COMMENTS

158-A-10  
 000336

Inspection Record

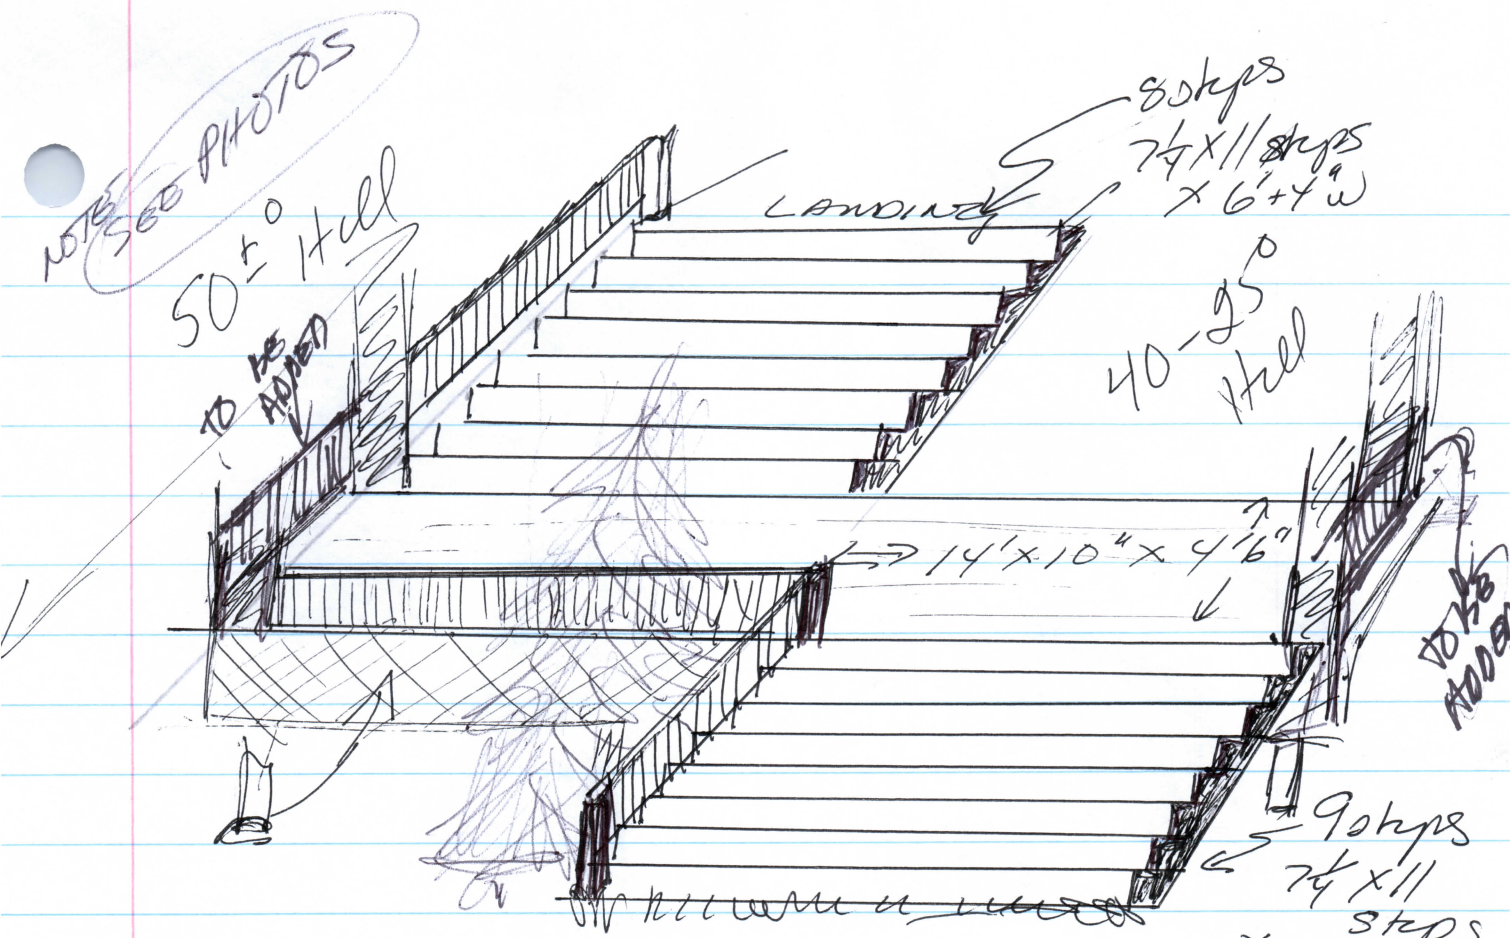
Issues on new deck -

OK PS# 1116LE 2305.2  
 1) Vertical 6x6's do not have fasteners to top side - substitute L Brackets on 2 sides of Ea Post -

2) Bottom Rail of new deck at 4 1/4 spacing - must be less than 4"

3) ~~Handrails~~ <sup>Handrails</sup> ~~must be 1 1/4" x 38" w/ smooth-rounded edges~~ - 1 1/4" x 38" w/ smooth-rounded edges

Need handrails both sides of stairs to grade - (stairs were existing -

any treads & risers replaced - Treads 9 1/2" net (except top is 9")

Risers 7 3/4" (except top is 9" - bottom will be built up to 7 3/4")

7/28 - 1st Insp by Mullitt - confirmed that existing stairs will require 2x4 handrails (P)

8/22 All correction made Final Inspection OK to close perm. (P)
